Planning Application Ref: **AW/270/20/T**

Location: **17 Margaret Close, Nyetimber, Aldwick, PO21 3AA**

Description of works: **Fell 1No. common lime tree**

TPO/AW/49/10

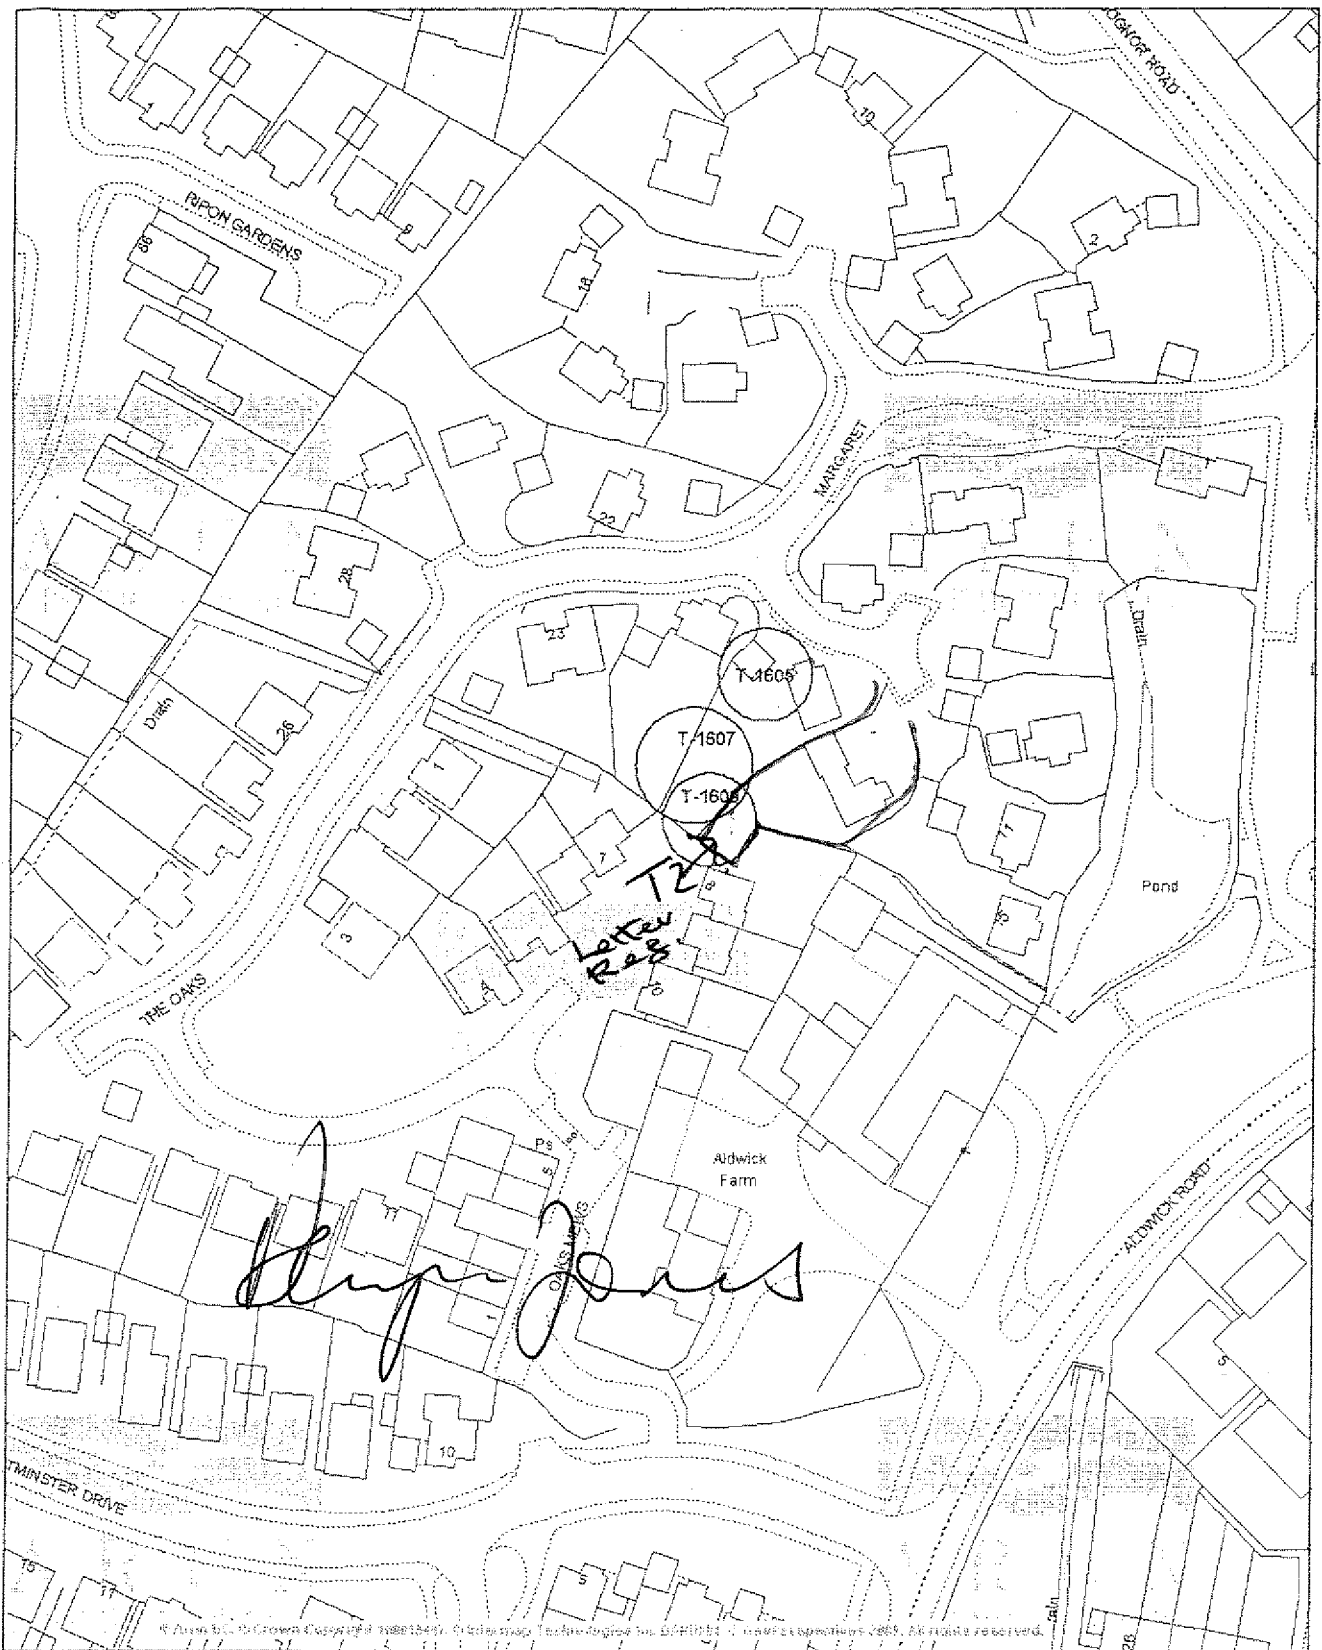
- There is contradictory information submitted in the application, such that we cannot be confident which tree is proposed for removal. The following details were provided:

- Annotated plan (from TPO/AW/49/10) assigning unique reference T2 but pointing to T1609 ash.
 - T2/T1609 is recorded on the TPO as being within the grounds of 19 Margaret Close.
